Application Reference: BN/152/24/DOC Site Name: Land at Angels Nursery Yapton Road Barnham PO22 0AY	Initial Issue Date: 23/04/2025 Issue Date: 13.04.2026 Reviewer Reference: ADC/EXT2/D2134/66
--	---

Summary and Recommendation:

Condition 3: **Further information required**

DRWG No: P19-2044_02 Sheet No:1 REV: D

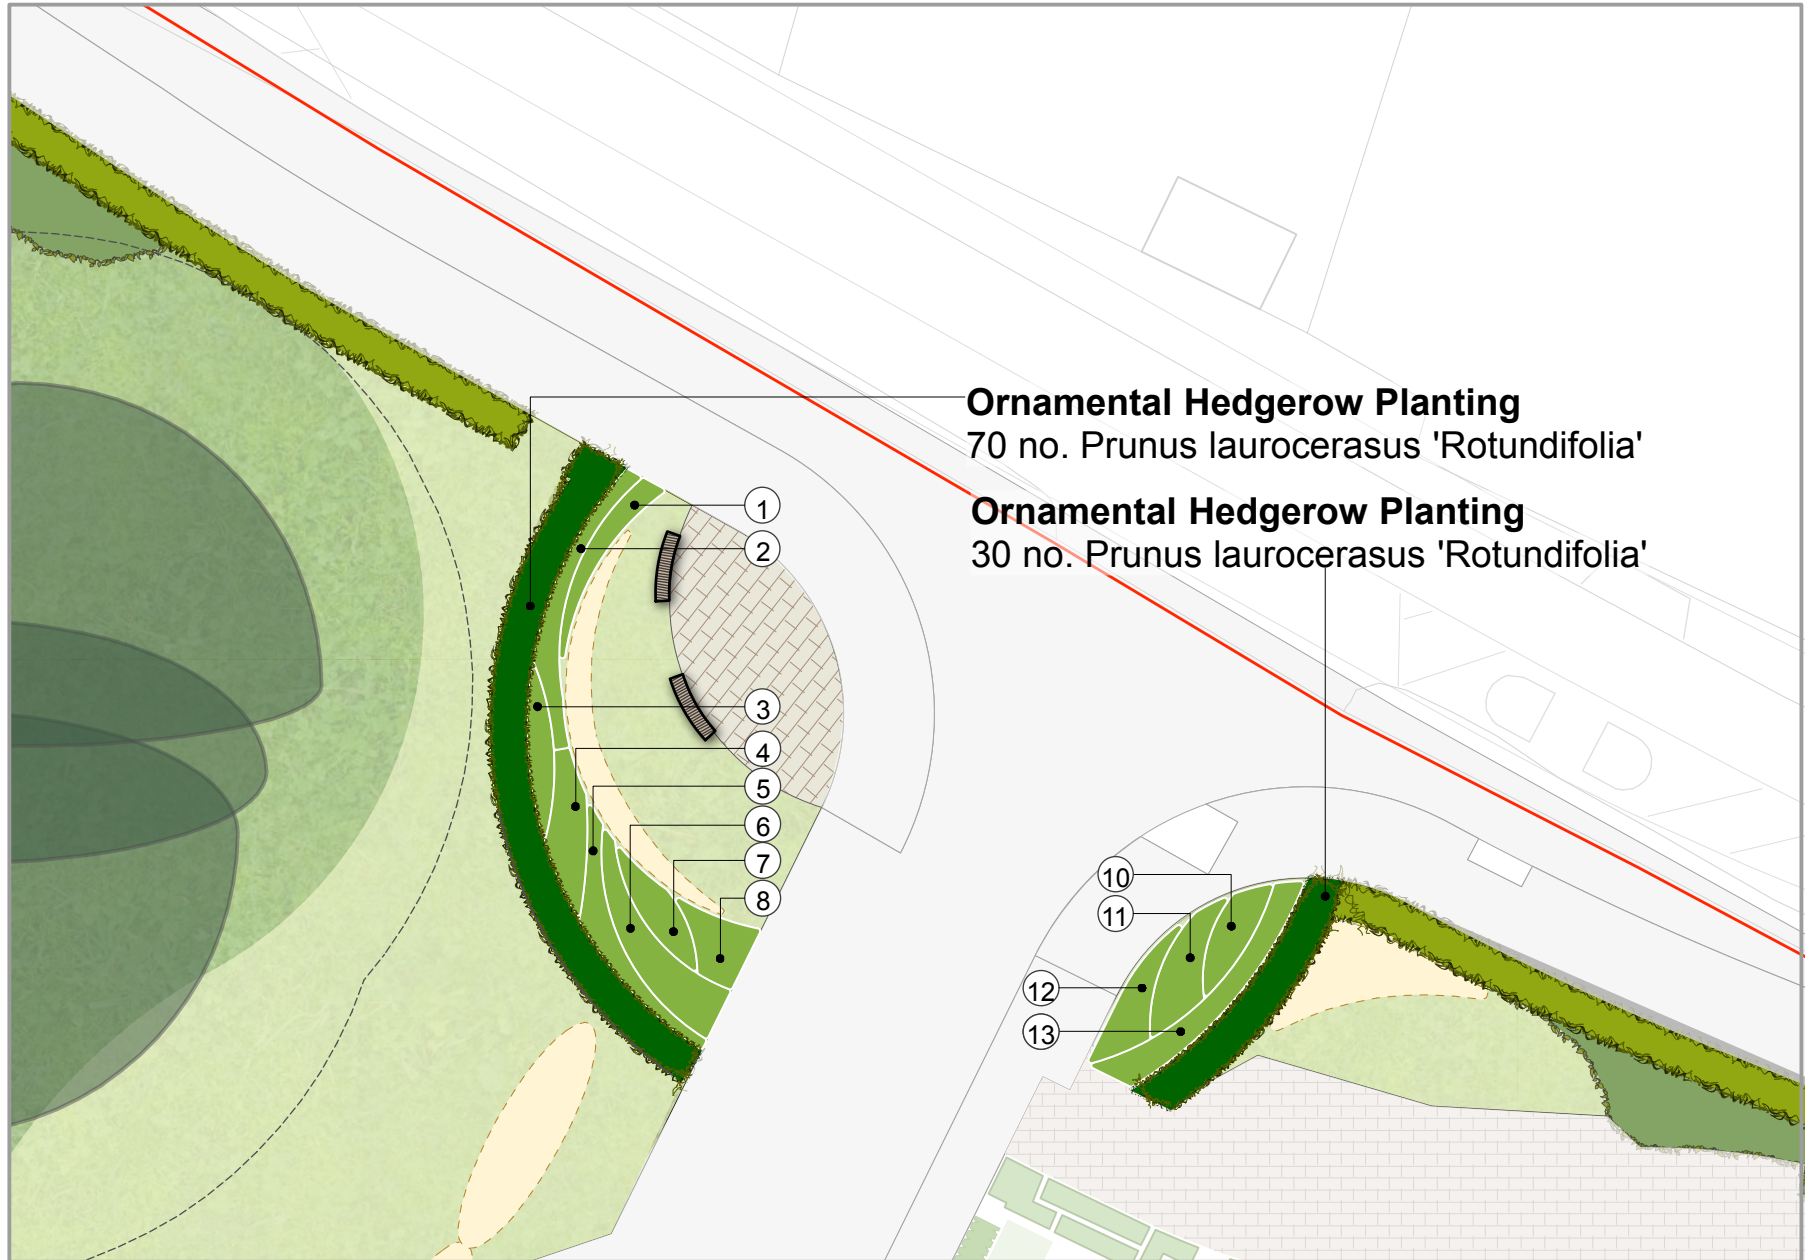
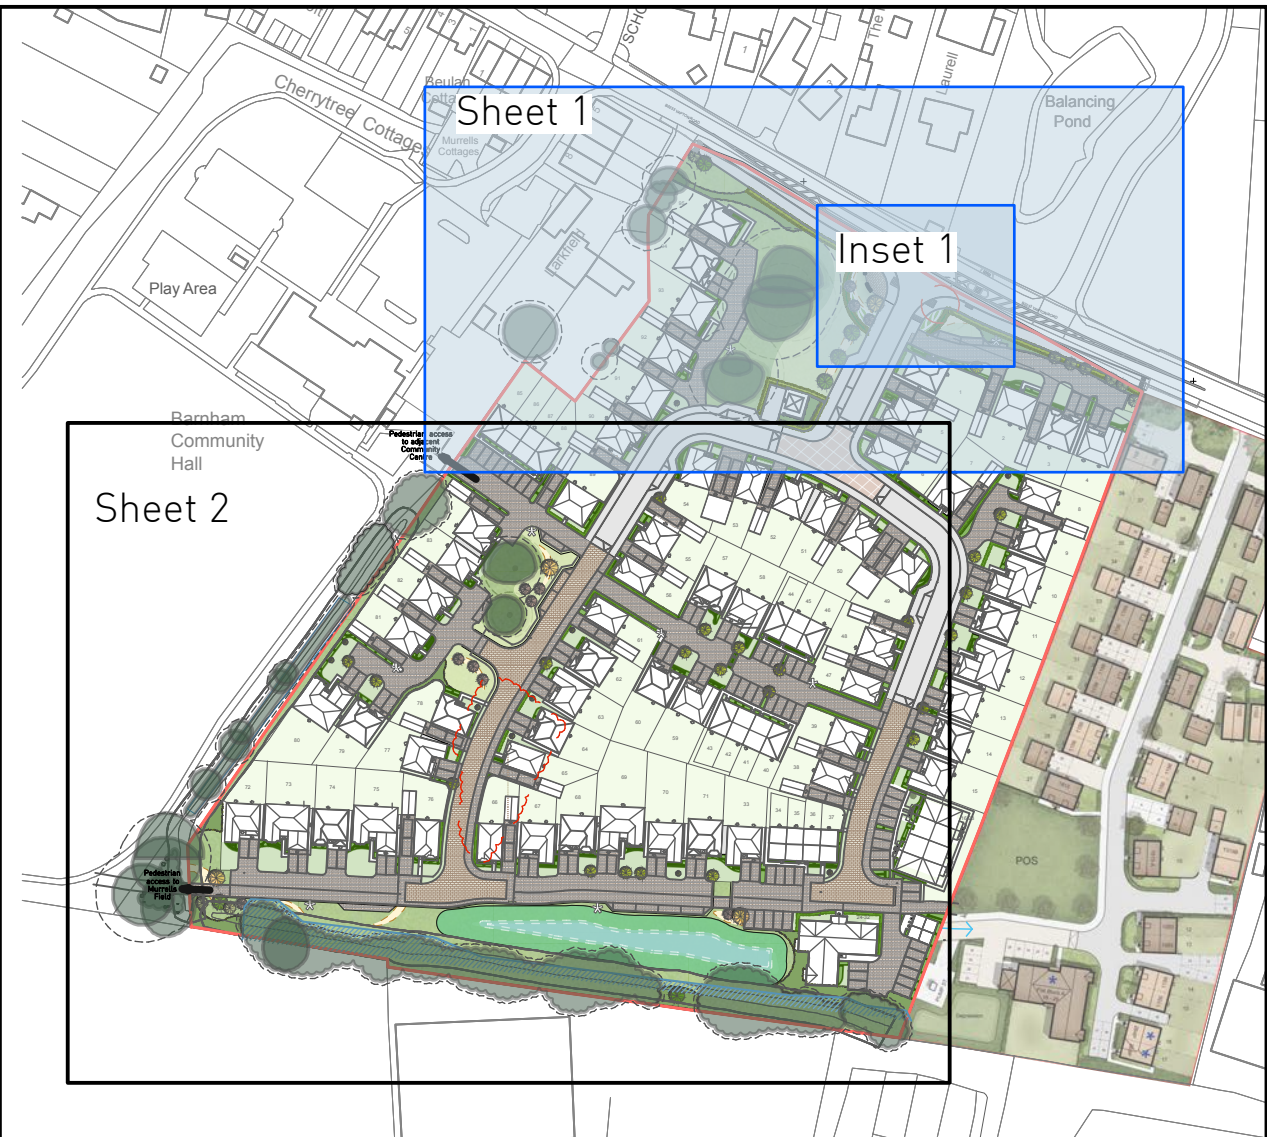
Comment Number					
1.	ADC Drainage Comments [BN/58/24/DOC] 24/05/2024: Please confirm that no new trees/landscape planting has been installed in areas which would be detrimental to the drainage infrastructure. Designer Response [BN/58/24/DOC] 09/07/2024: Dropbox link contains the approved landscaping plans. All landscaping has been instructed in accordance with these plans. ADC Response [BN/58/24/DOC] 10/09/2024: The landscaping drawing (P19-2044_02) for the public open space appears to be based on a different site layout. Please provide the correct landscaping drawing. ADC Response (BN/152/24/DOC) 15/01/2025 Landscaping drawing P19-2044_02 has been supplied as before. In addition another landscaping drawing for 'enhanced proposals' (Covey Design) has been supplied reference 17890 02 Rev B. Both drawings however are based on a different site layouts compared to the SUDS/engineering plans that we understand have been implemented.	The landscaping drawings provided are approved drawings. Landscaping on site has been carried out in accordance with these drawings. The information submitted shows that no trees/landscaping has been installed in areas which are detrimental to the drainage structure.	The applicant has not verified this response. An example can be seen below where the drainage GA appears to be conflicting with one of the landscaping proposals for the access to plot 81? Has landscaping been installed as per these drawings? Comment outstanding. 	The Landscaping Proposals have now been revised to relocate the 3no. Magnolia trees within the open space opposite plot 81 to avoid the easement associated with the existing surface water pipe.

Please provide the landscaping proposals that have/will be installed to the final site layout. Designer Response (BN/152/24/DOC) 04/02/2025 The approved landscaping plans are clearly defined in section 2.1.4 within the report are presented in appendix A for reference. These are the drawings that are documented in associated planning decision notice/ approval. ADC Response (BN/152/24/DOC) 23/04/2025 To clarify the earlier comment, it would appear that both drawings however appear to show different planting proposals so there is some uncertainty of planting to be reviewed in vicinity of the drainage and SUDS features. Please provide the landscaping proposals that have/will be installed to the final site layout.

1. The Pond

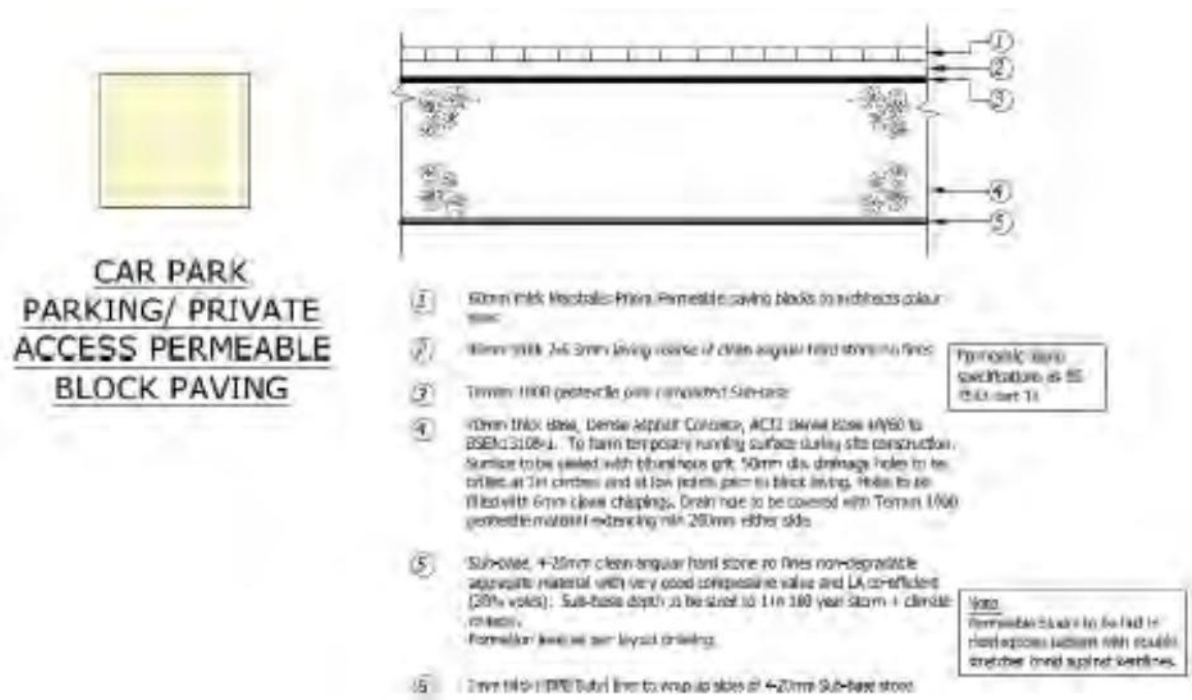
2.	ADC Comments [BN/58/24/DOC] 10/09/2024: Encompass survey ref: ENC/270624/3459/S1. This shows that the as constructed storage pond levels differ to the design levels and it is shaped differently. This is further shown on drawing CBE-RR-BARNHAM ORTHO AB 01. Please demonstrate that this is not detrimental to the surface water drainage system. ADC Response (BN/152/24/DOC) 15/01/2025 This is fundamental where the base levels (higher) and top of bank levels vary (lower) and may increase the risk of flooding to 3rd party land. Designer Response (BN/152/24/DOC) 04/02/2025	Please see submitted drawings which indicate the top of the bank.(Ref: Swale Survey 12/06/25)	Noted. The as-built string of levels along the southern boundary is compliant with the proposed basin/earthwork design with freeboard. Comment closed.

Please refer to the as built calculations and section 6.2 of the report, which demonstrates the as constructed network remains in accordance with the design scheme hydraulic modelling output as approved at planning. ADC Response (BN/152/24/DOC) 23/04/2025 Response insufficient. The as-built topo survey shows the southern top of bank top be of the order of 9.01-9.17 for most of the length and the 'asbuilt' calculations show the water levels in the network exceeding this thus there is no freeboard.

Response insufficient. The as-built topo survey shows the southern top of bank top be of the order of 9.01-9.17 for most of the length and the 'asbuilt' calculations show the water levels in the network exceeding this thus there is no freeboard.
